Application No: M/47/21/HH
Site Address: 22 Tudor Close Middleton-On-Sea PO22 6DN
Description of works: Removal of existing roof structure, new first floor accommodation and pitched roof above and replacement rear two storey extension and new front porch extension.

Thank you for your internet representation made on 13th May 2021 which has been recorded as an objection with the comments as follows:

REAR ELEVATION

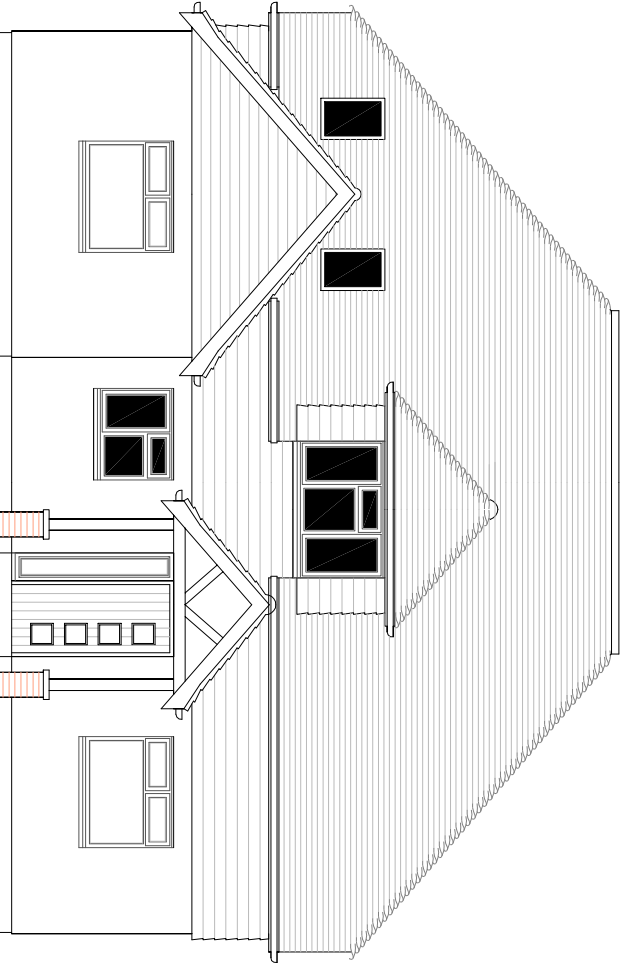
The proposed rear elevation is now visually dominated and out of character and spatial pattern of the roof scape on the surrounding buildings.

The size and number of first floor windows on the rear elevation has increased from the previous rejected application and the external wall is now approximately 4 meters closer to the southern boundary. The glazed area of the first floor windows has almost doubled from the previous proposal.

The proposal will result in an elevation which is out of character with surrounding buildings and will have an unacceptable loss of privacy for us and the surrounding neighbours.
